**KIRKLEES METROPOLITAN COUNCIL
INVESTMENT & REGENERATION SERVICE**

DELEGATED DECISION TO DETERMINE PLANNING APPLICATIONS

| Reference No: | 2025/62/91128/E |
| Description: | Extension of farmyard and erection of cattle building |

M WORSLEY, PROPOSED CATTLE BUILDING AT HEALEY FARM, HEALEY LANE, BRIESTFIELD, DENSBURT, WS12 0NT
ELEVATIONS (1) + FLOOR PLAN (1) 1:200 @ A3 OVER 2 SHEETS APRIL 2025

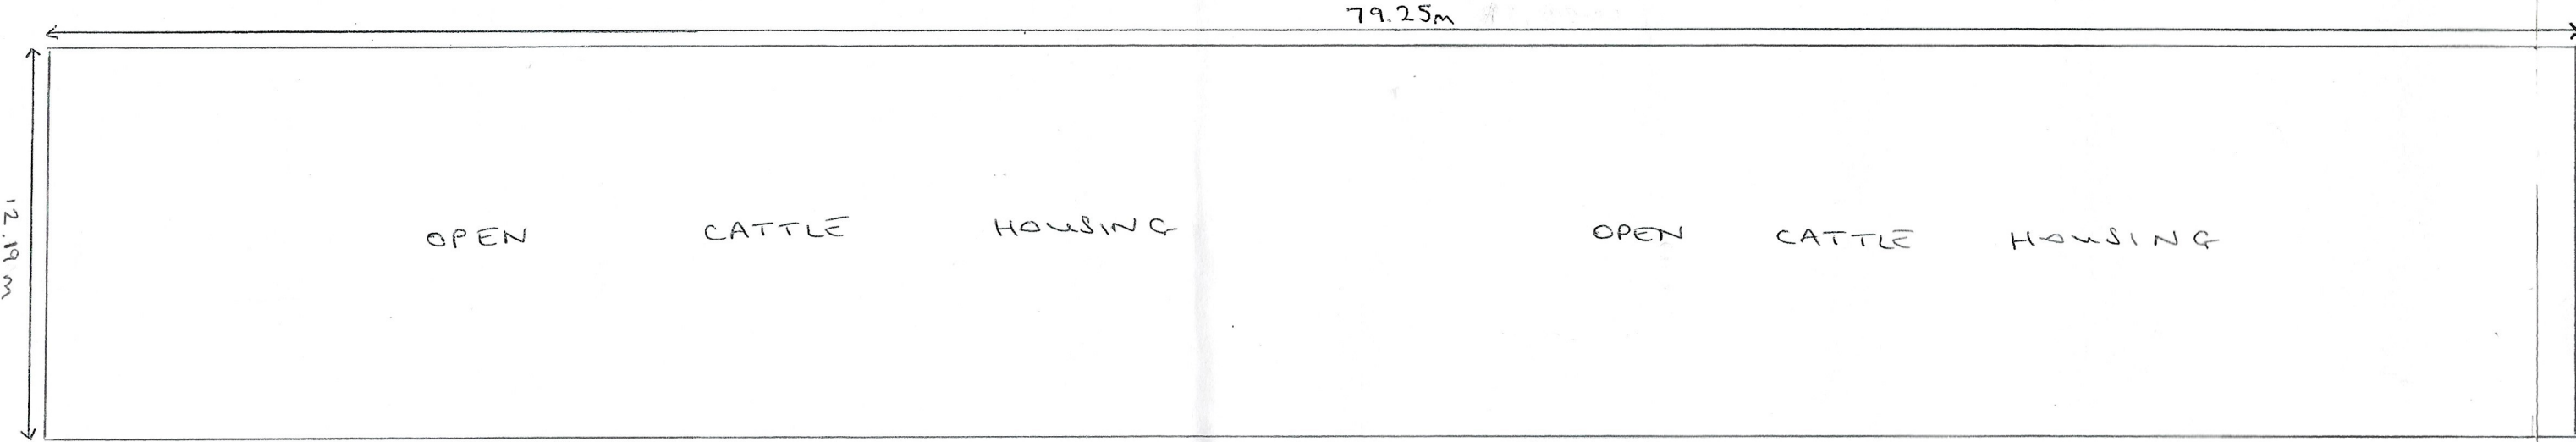
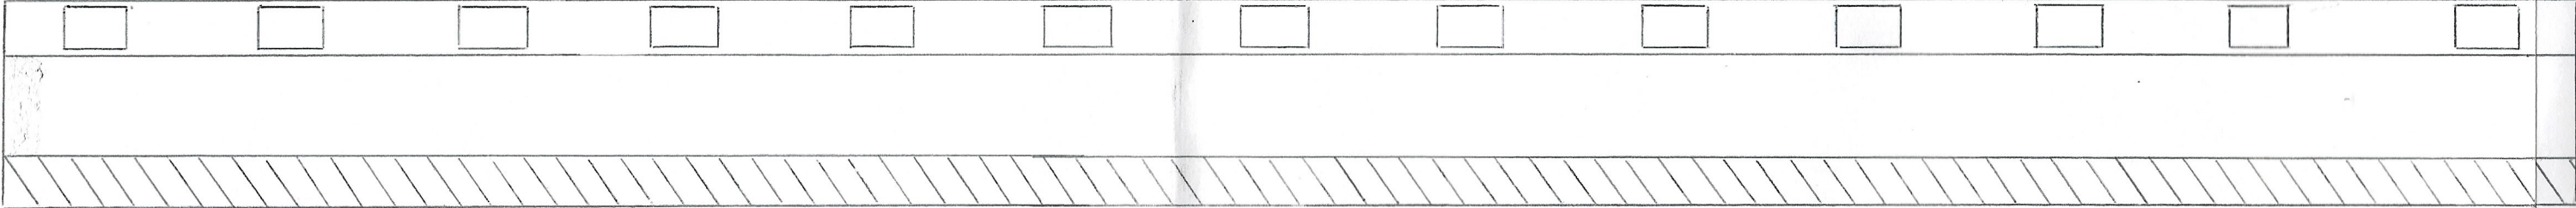
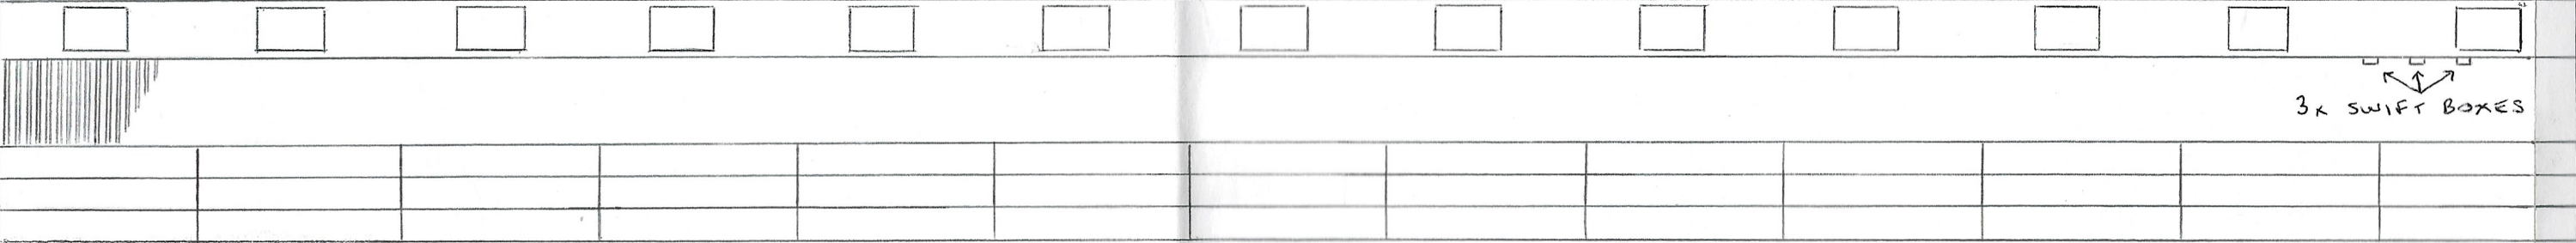
- The cattle building would have an overall length of approx. 79.25m, a depth of approx. 12.19m and a height of approx. 6.3m to 7.5m due to the topography of the site.
- Construction materials – timber Yorkshire boarding with concrete panels below for the external walls and grey fibre cement sheets for the roof
- The existing farmyard would be extended 3.69m (317sqm in total)

- The route of the public footpath is not shown on the submitted plans, but it looks like it will be obstructed by the proposed new building, which will be an offence.
